Consultation Response from KC, Lead Local Flood Authority
2023/93704 land northwest of, Urban Terrace, Denby Lane, Grange Moor, Huddersfield, WF4 4EB
Erection of 12 dwellings and associated works
Date Responded: 15 th November 2024 Responding Officer: Paul Farndale Responding Ref:

THE LLFA OBJECTS TO THIS APPLICATION.

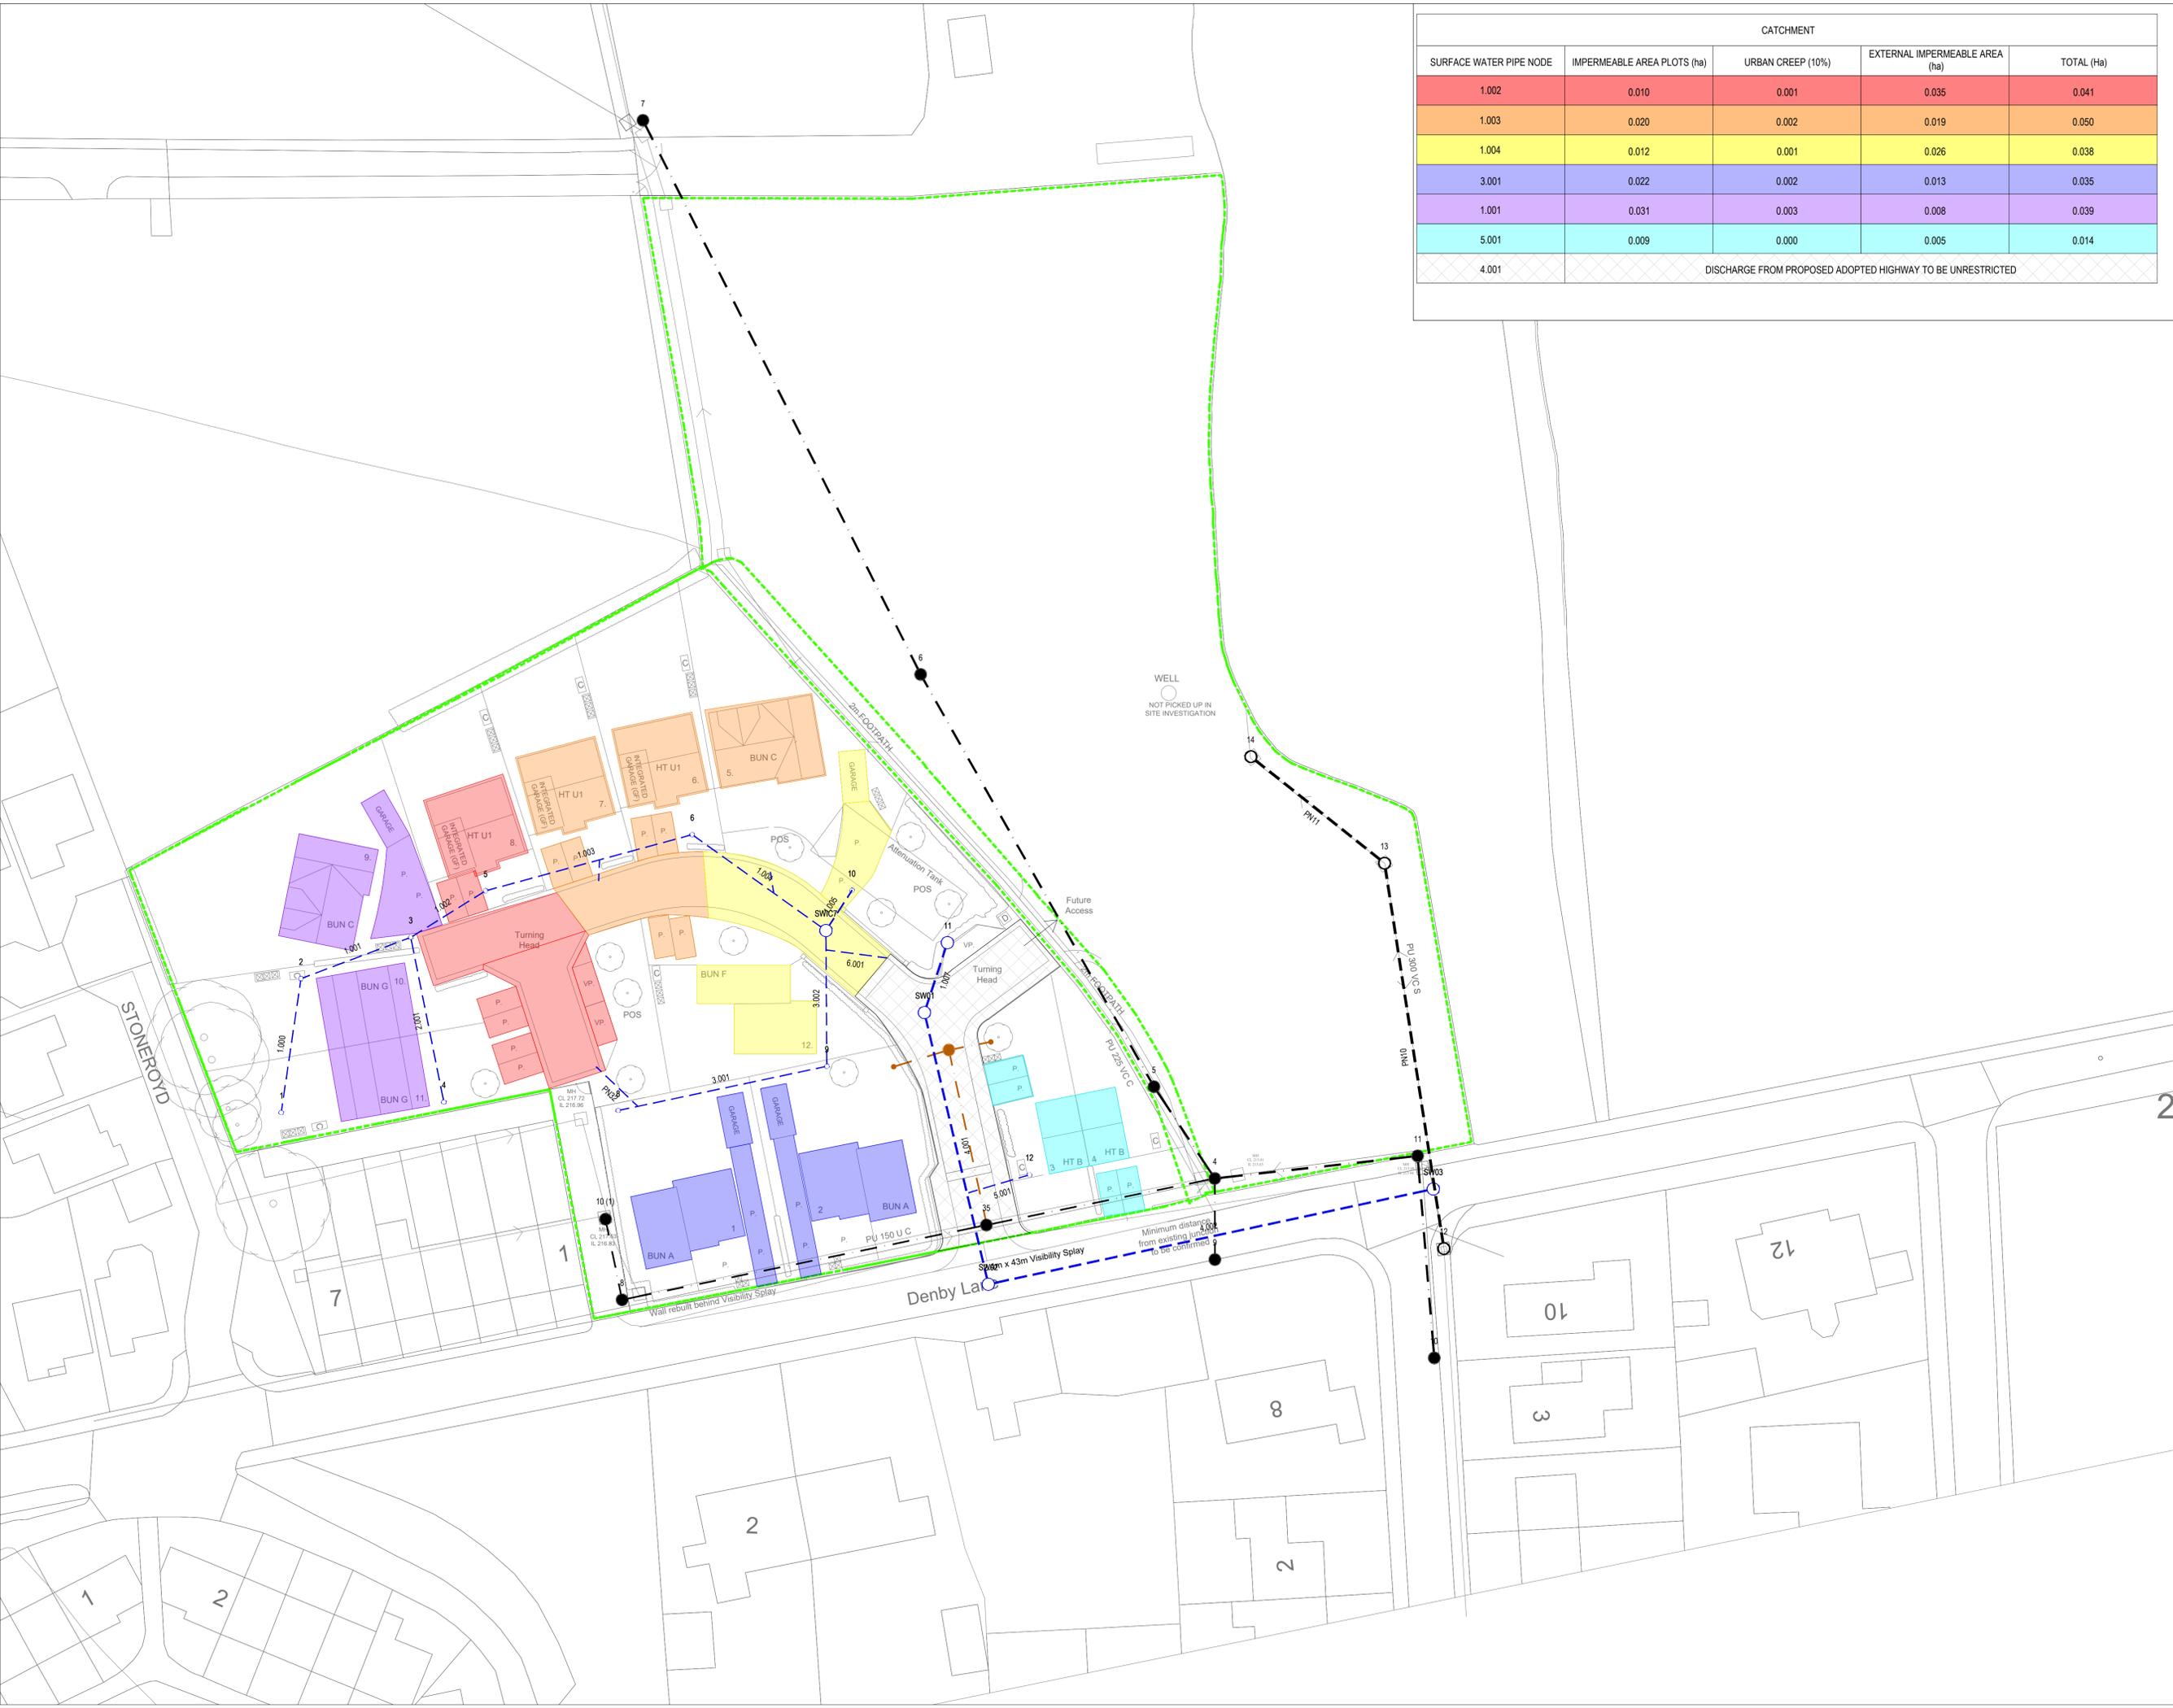
The Engineering Layout Y22054/D900 has been updated with revision 2. This still shows existing public highway gullies connected to the new pipework. We continue to deem this unacceptable to the Council as the Highway Authority.

The drawing continues to show both new highway, existing highway and house drainage (plots 3 and 4) connecting to the proposed surface water system after the flow control device and therefore will exceed the allowed 3.5l/s. As this system ultimately connect to watercourse the LLFA has the final say in this matter as Land Drainage Authority and we maintain our objection.

The planning officer should be made aware of potential level rises over the attenuation tank mentioned on this drawing to provide adequate cover, i.e. land levels raised in this area in relation to the surroundings.

The submission of 'Impermeable Area Plan Y22054-D204-Rev1 (uploaded 31/10/2024)

This plan confirms that the road network and plots 3 and 4 connect downstream of the flow control device and allow a greater discharge than has been recommend. Please note that connections from plots 3 and 4 have altered position and is therefore out of kilter with previously submitted drainage plans as part of the SUDS Management Plan. The SUDS maintenance plans will need updating but we recommend this is done when a drainage layout can be agreed.

The submission Revision 3 of Engineering Layout Y22054/D900

This drawing's layout replicates the impermeable area plan but not to the previous revisions in the Suds Management Plan. All aspects of drainage mentioned regarding maintenance and adoption, and flows greater than the allowed 3.5l/s, still stand. No microdrainage calculations or equivalent have been provided. However as we object to the drainage drawing these should not be submitted until such a time that an update is agreed in principle.
